Your Ref: LU/330/18/PL

RE :- Land South of Cornfield Close, Littlehampton BN17 6LD

Thank you for your correspondence of 27th November 2018, advising me of the 'Demolition of existing buildings & the erection of 77 residential homes with associated access, car parking, cycle parking, refuse/recycling storage, landscaping, earthworks & infrastructure' application for which you seek advice from a crime prevention viewpoint.

Drawing
Proposed Block Plan

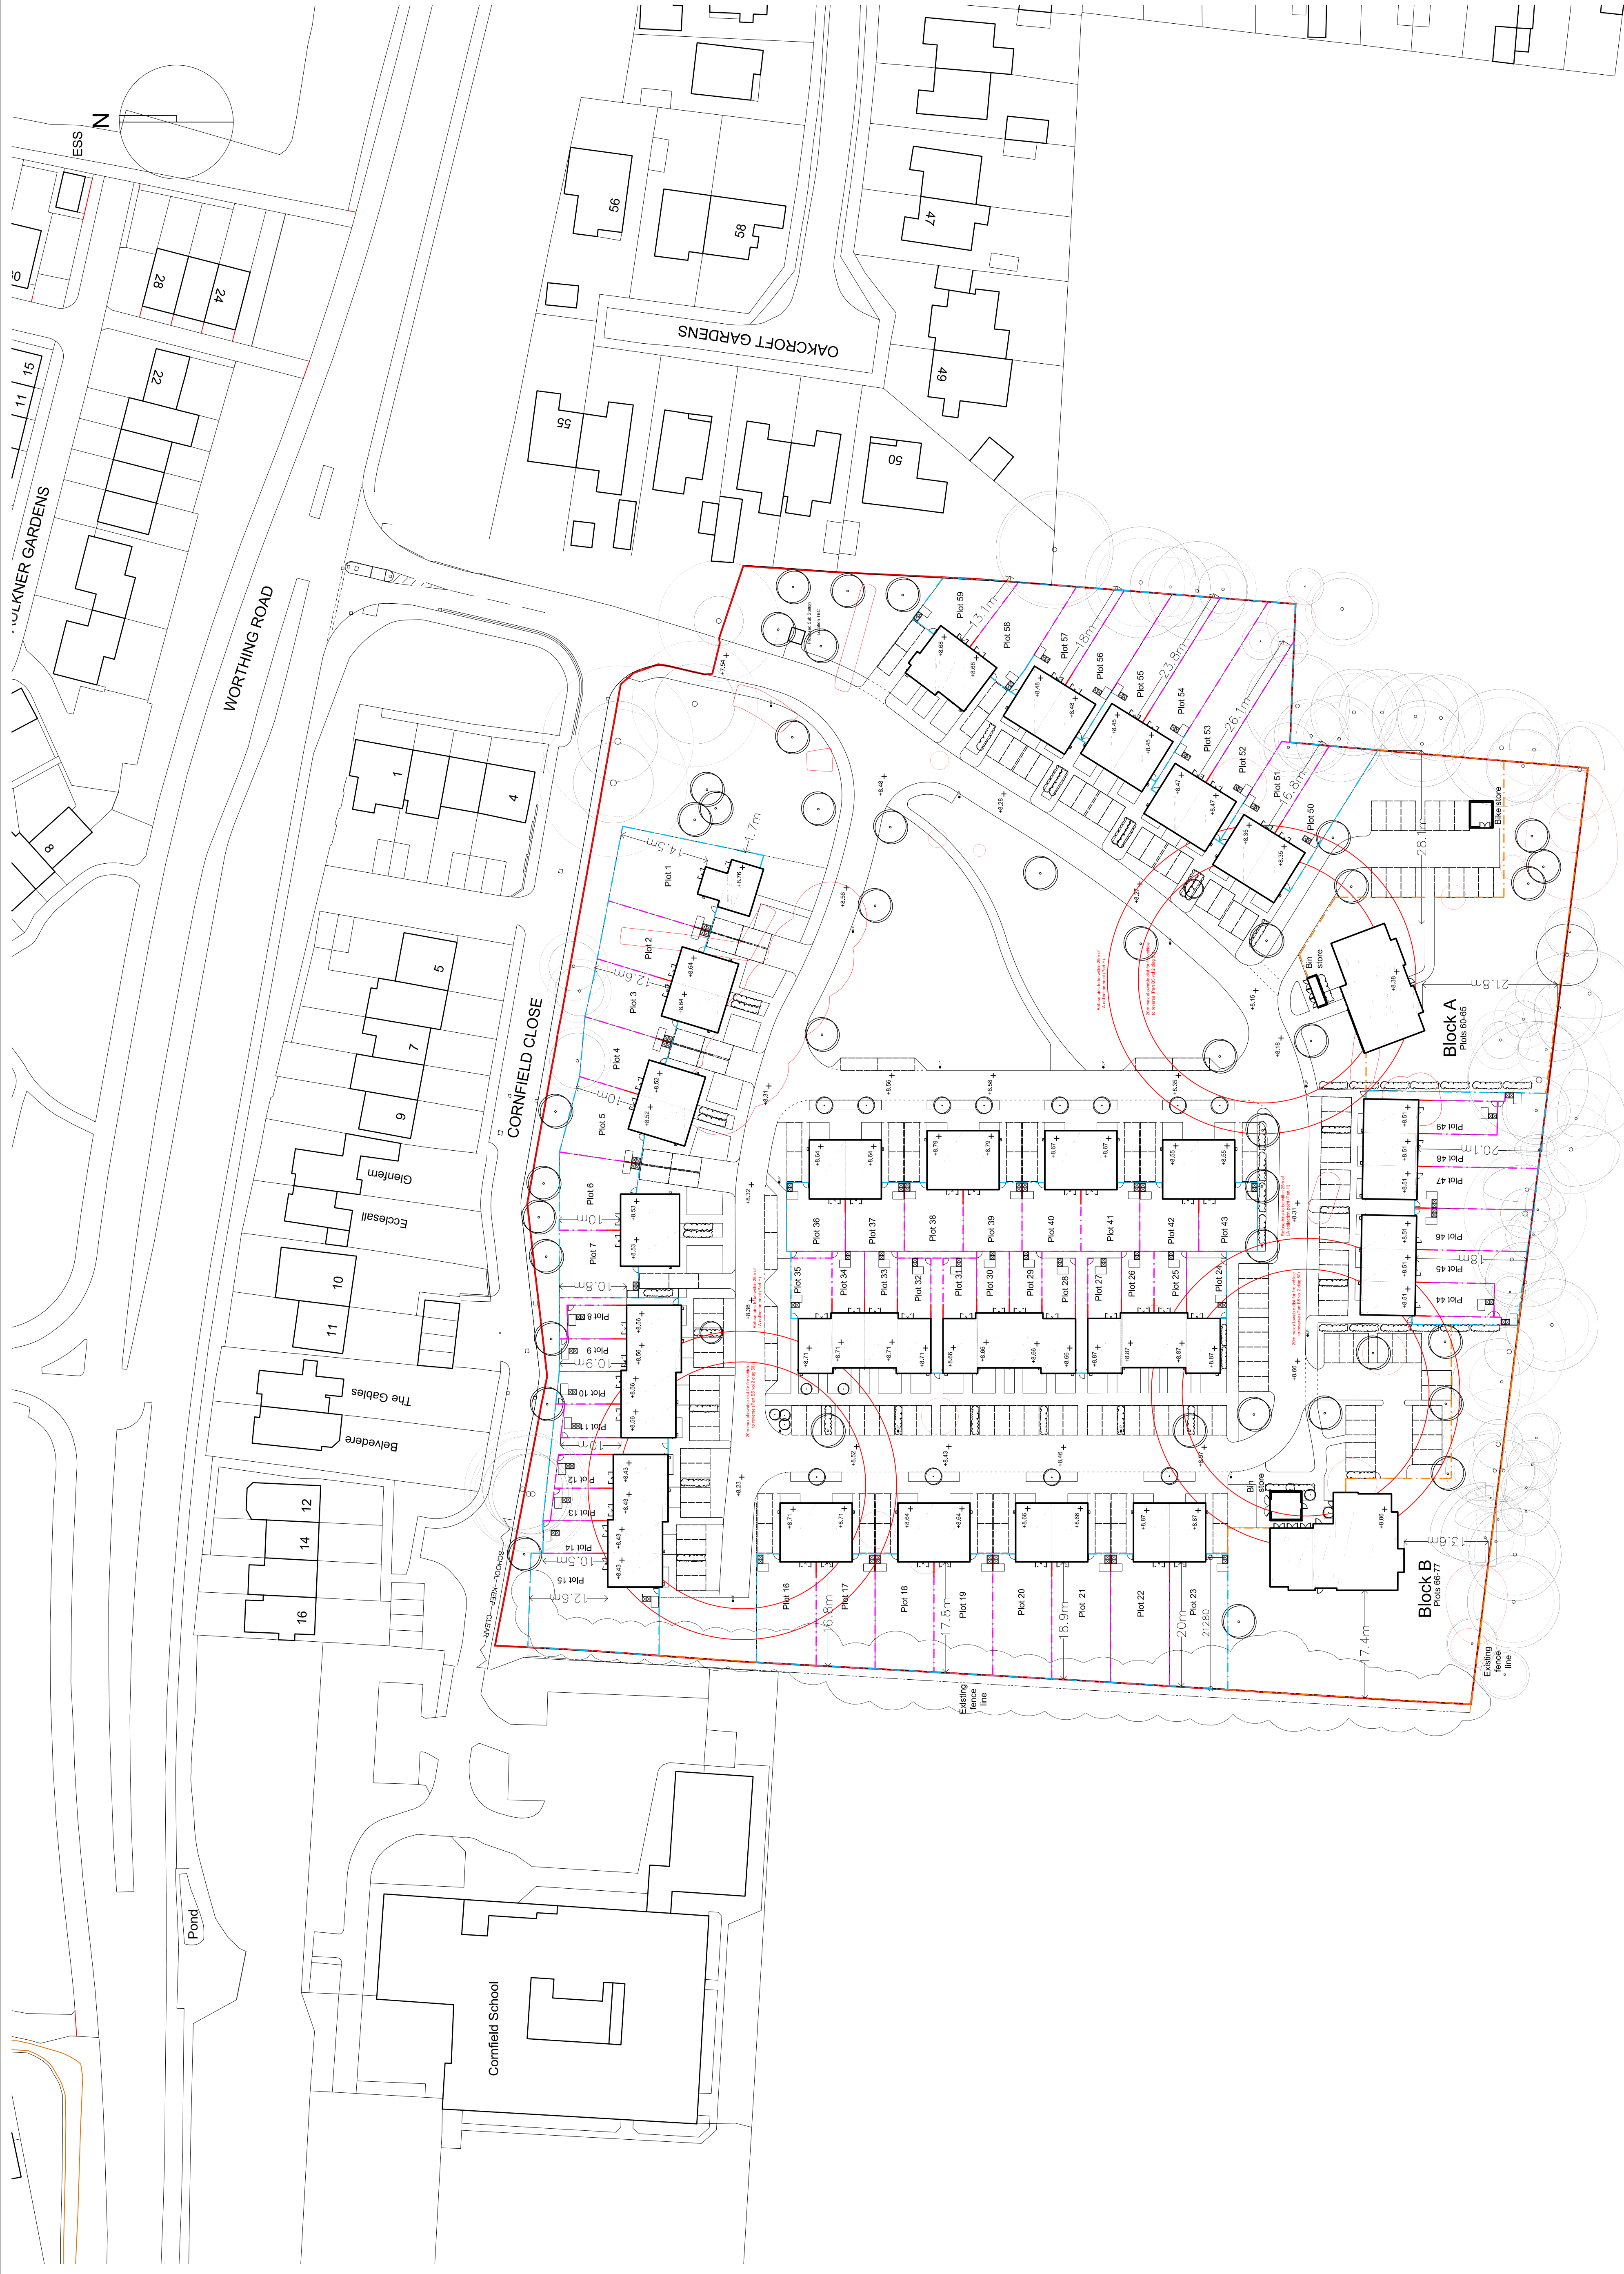
As the first line of defence, perimeter fencing must be adequate with vulnerable areas such as side and rear gardens needing more robust defensive barriers by using walls or fencing to a minimum height of 1.8metres.

In circumstances that require a more open feature such as a garden overlooking a rear parking court or a rear garden pathway, 1.5 metre high close board fencing topped with 300mm of trellis can achieve both security and surveillance requirements. This solution provides surveillance into an otherwise unobserved area and a security height of 1.8 metres.

Gates that provide access to the side of the dwelling or rear access to the gardens must be robustly constructed of timber, be the same height as the adjoining fence and be lockable from both sides. Such gates must be located on or as near to the front of the building line as possible.
